SPR EA1N and EA2 PROJECTS

DEADLINE 6 – POST ISH7 HEARING ON BIODIVERSITY AND HABITATS REGULATIONS ASSESSMENT AND POST HEARING WRITTEN SUBMISSION OF ORAL CASE

PART 1 Agenda item 2 a - Hundred River

Interested Party: SASES **IP Reference Nos.** 20024106 and 20024110

**East Anglia ONE North and East Anglia TWO**  
Hundred River and Statutory Designated Sites Location

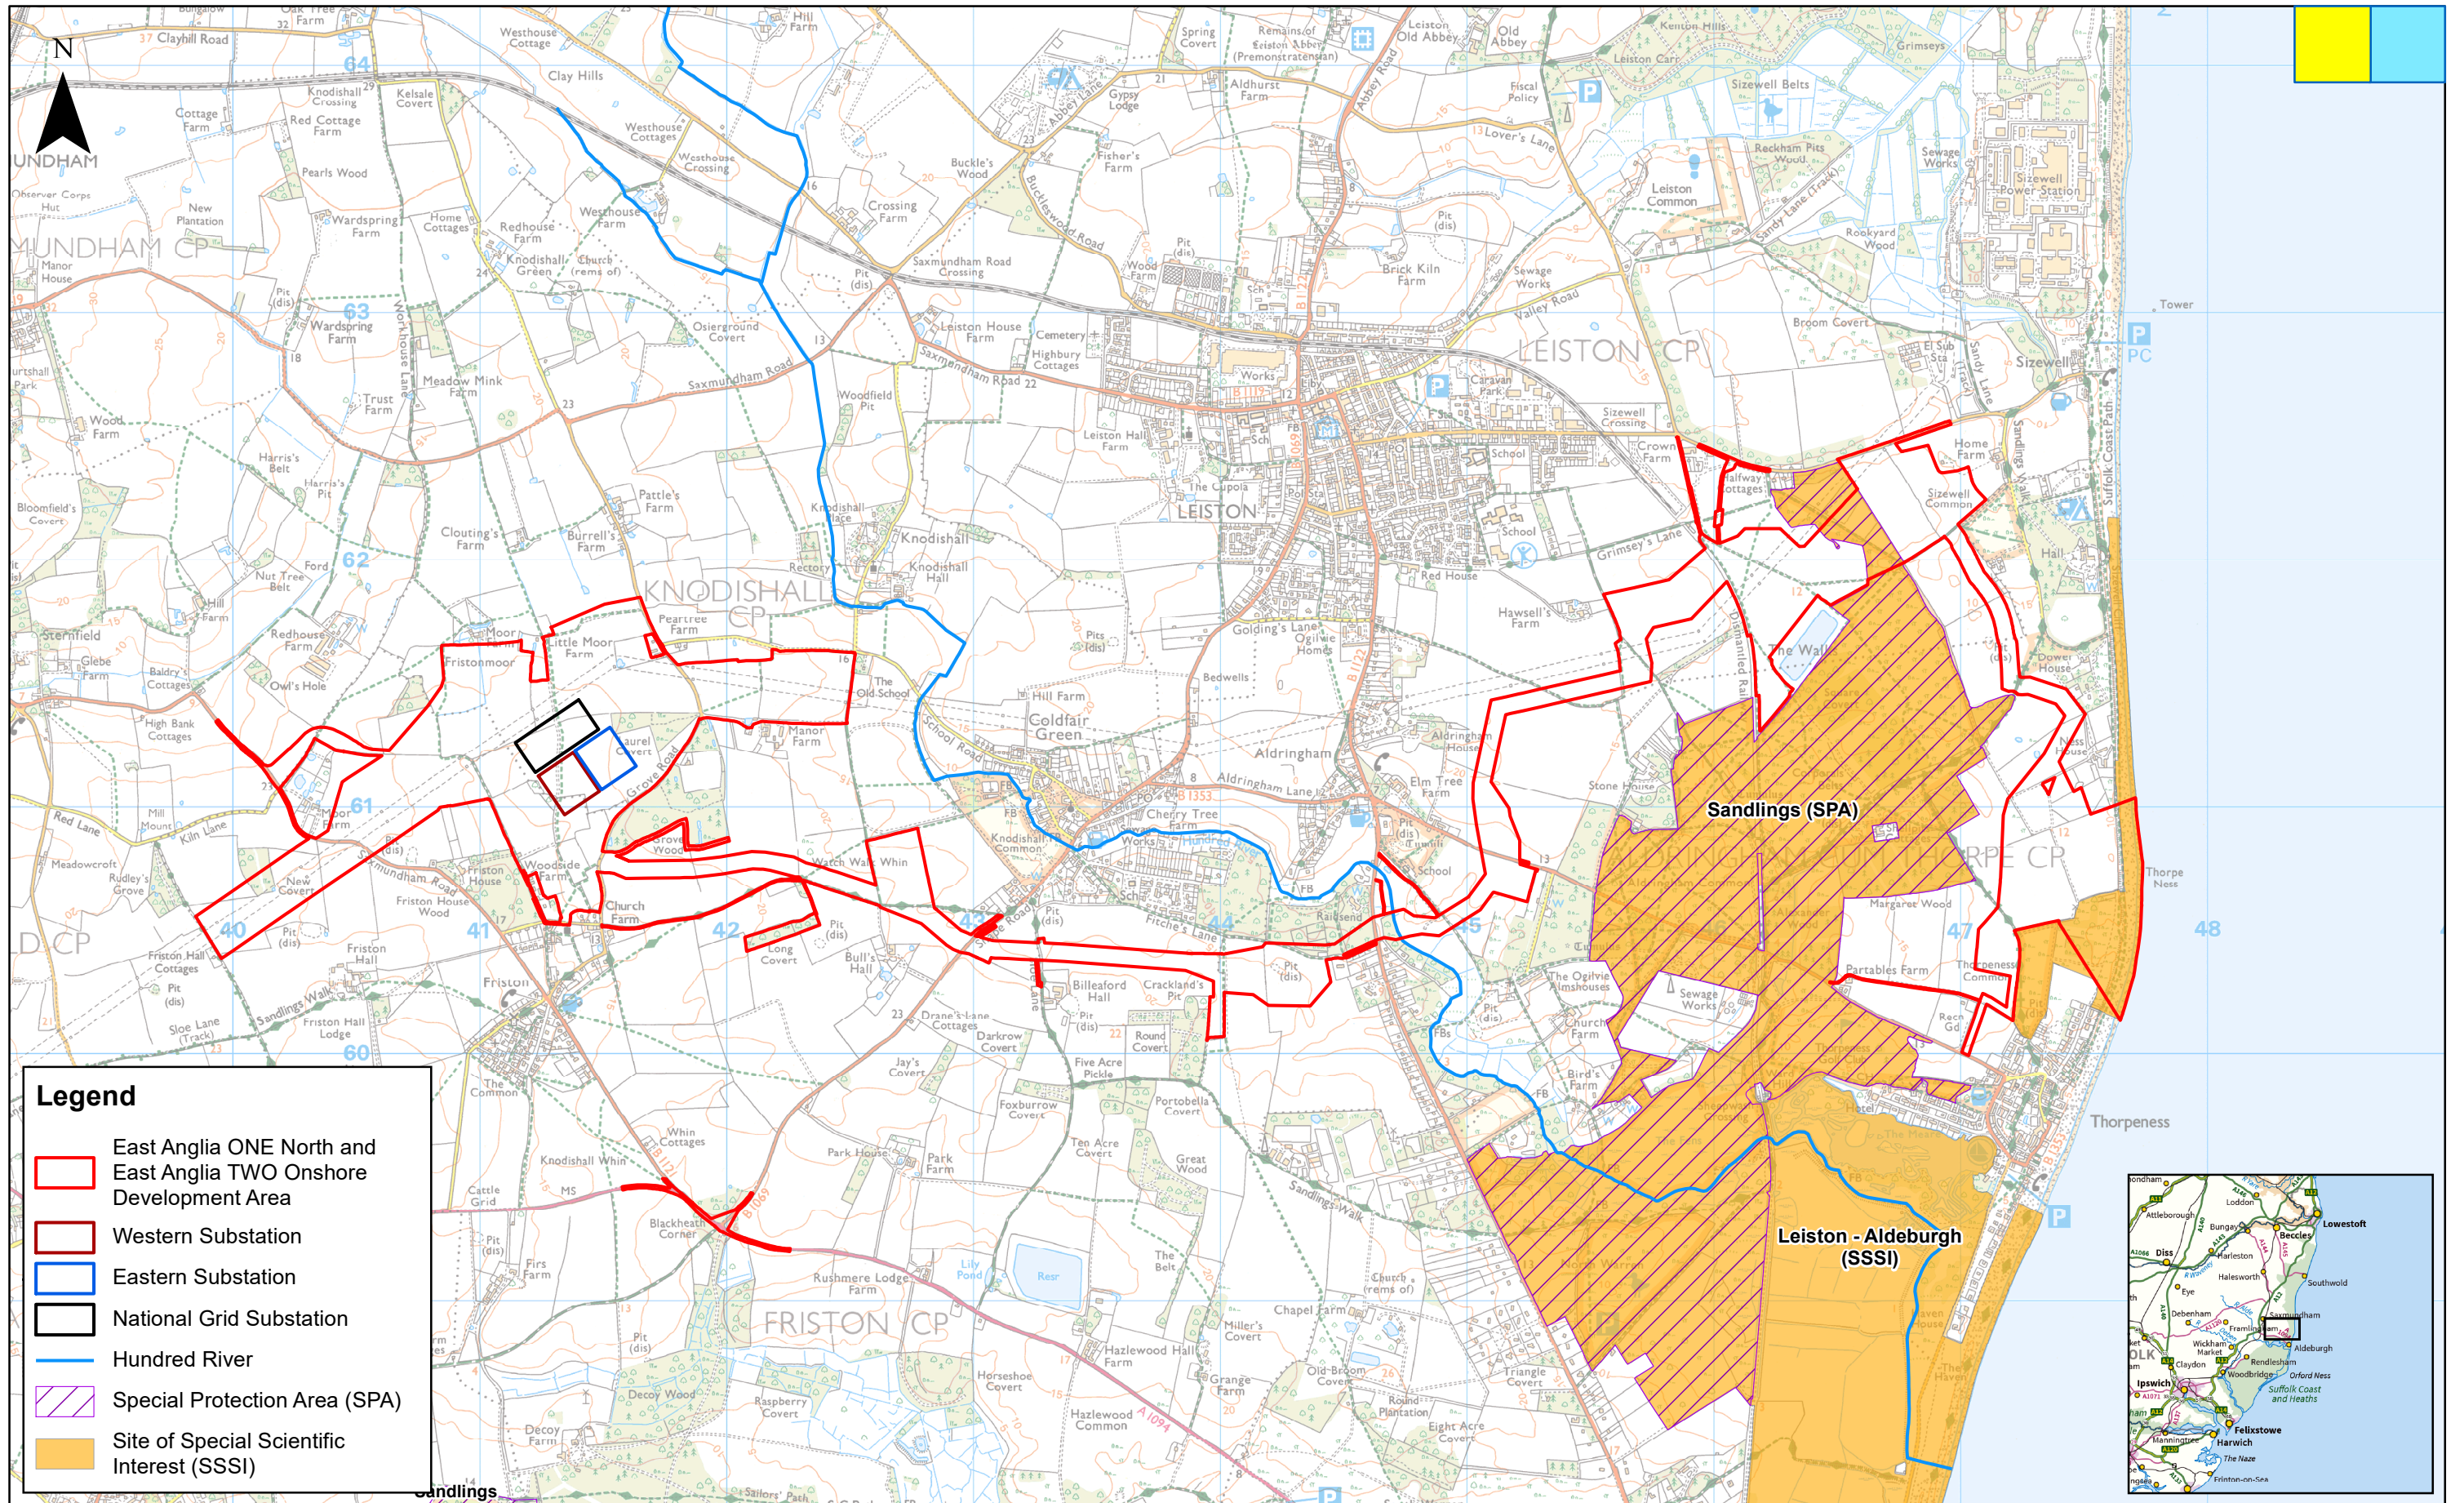
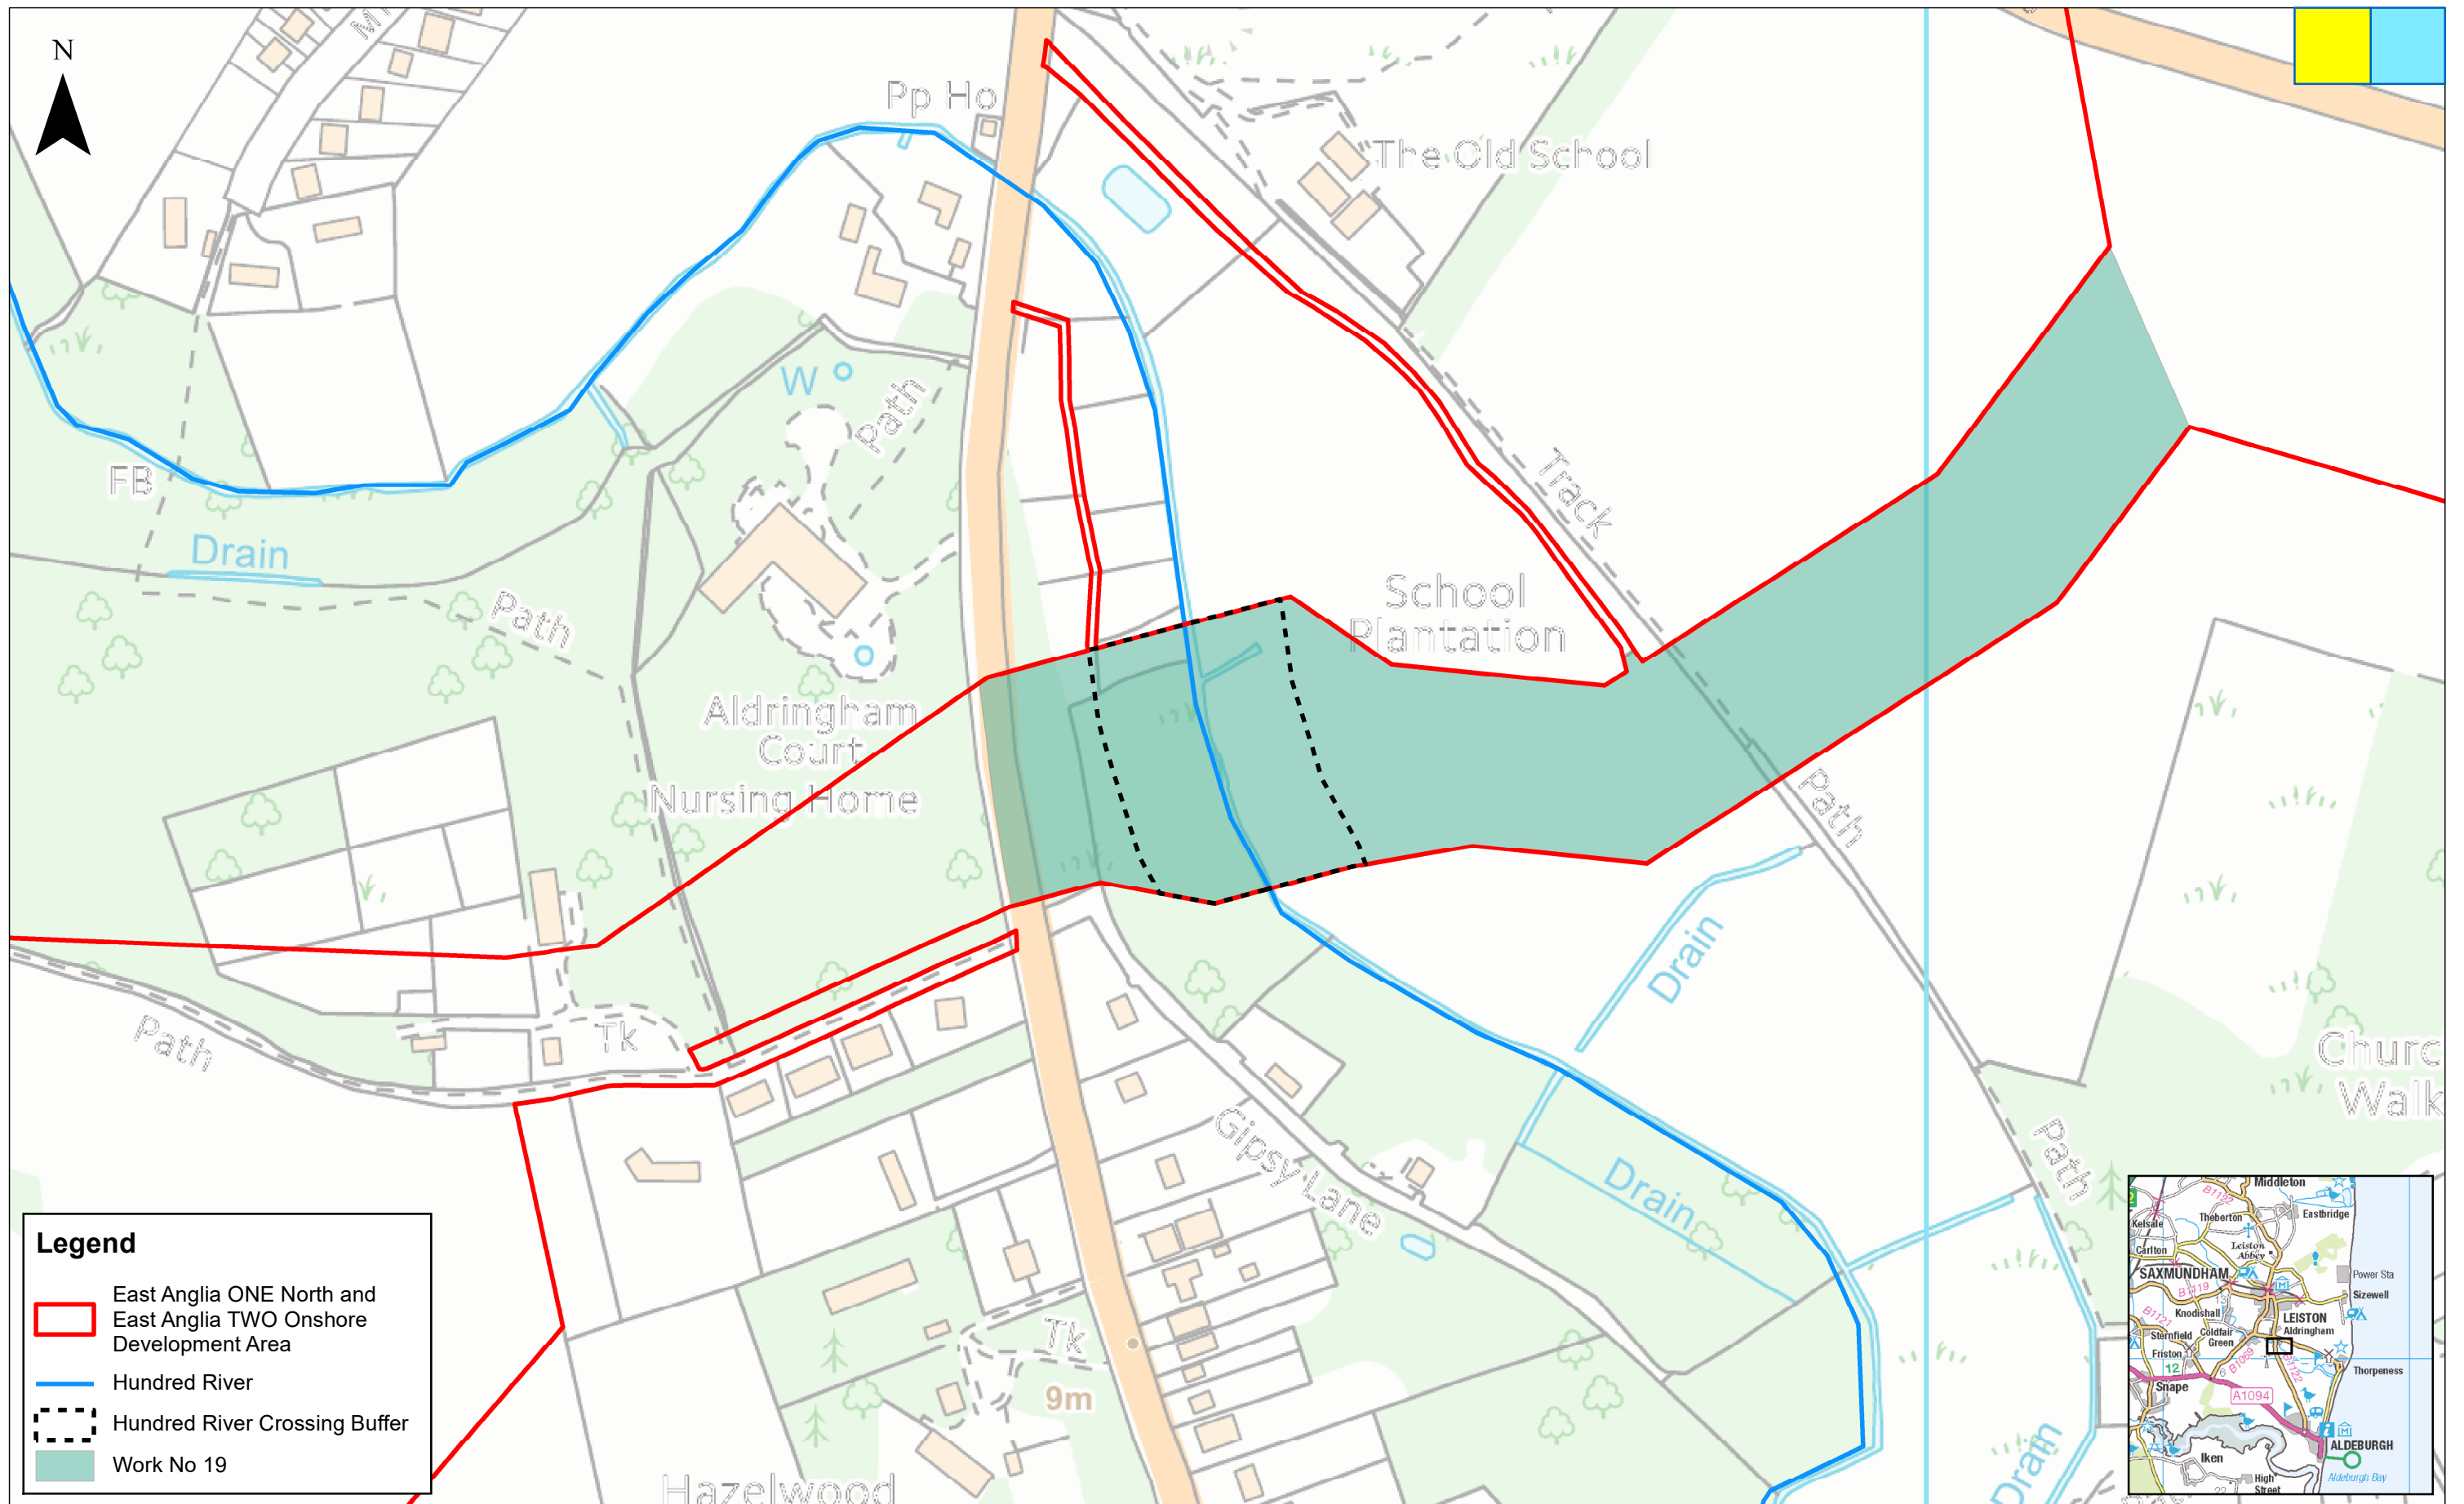
16. The Applicants had responded to several of the Panel's earlier ExQ1 questions regarding the R Hundred crossing, essentially to the effect that they would much prefer to use an Open/Cut trenched approach across the R. Hundred rather than an alternative 'trenchless' approach and tunnelling under the river. The Applicants identified certain disadvantages of using trenchless methods at that location, but on the assumption that HDD is the only alternative method that would avoid risk to the watercourse, its neighbouring habitats and further downstream, to the Sandlings SPA including North Warren Nature Reserve.

17. The Applicants' Methodology does not say anything about other non-HDD trenchless methodologies. It has not provided any information on the feasibility and comparative advantages that might accrue from using micro tunnelling instead of Open /Cut trench.

18. SPR's Ground Engineering Consultants first mentioned micro tunnelling at SPR's Community Consultation events as being a potentially less intrusive technical solution than HDD for the installation of underground power cable ducts, indicating that it might be feasible to construct a cluster of tunnels from a point east of the R Hundred underneath all of the following vulnerable features:

- the river itself
 - under the section of riparian woodland discussed under Agenda item 2 (i)
 - under the B1122 Aldeburgh Road
 - and finally beneath the Group TPO [SCDC/87/00030] woodland to the west of Aldeburgh Road, between Fitches Lane and Aldringham Court

emerging at a point beyond the woodland protected under and well away from human habitation. The distance involved (200 - 300 metres according to the Works Plans) should be within the capabilities and experience of a Civil Engineering specialist contractor.

19. Such a solution might not only mitigate, but **eliminate** much of the prospective damage to biodiversity in Aldringham, including loss of woodland, the risk of flooding during construction, B1122 traffic delays and interruptions to utility services. However, it must be recognised that even micro tunnelling could also bring substantial disturbance and perhaps other problems to residents living close by. Such matters would have to be weighed up against the benefits.

- SASES [REP5-098] Further comments on Applicants' Watercourse Crossing Method Statement
22. We ask that the Applicants commit to publishing their expert report (which may already be to hand) on the feasibility, benefits and dis-benefits of a micro tunnel solution to protect the River Hundred, its riverside habitats, the TPO woodland west of B1122 and the road crossing as described above.
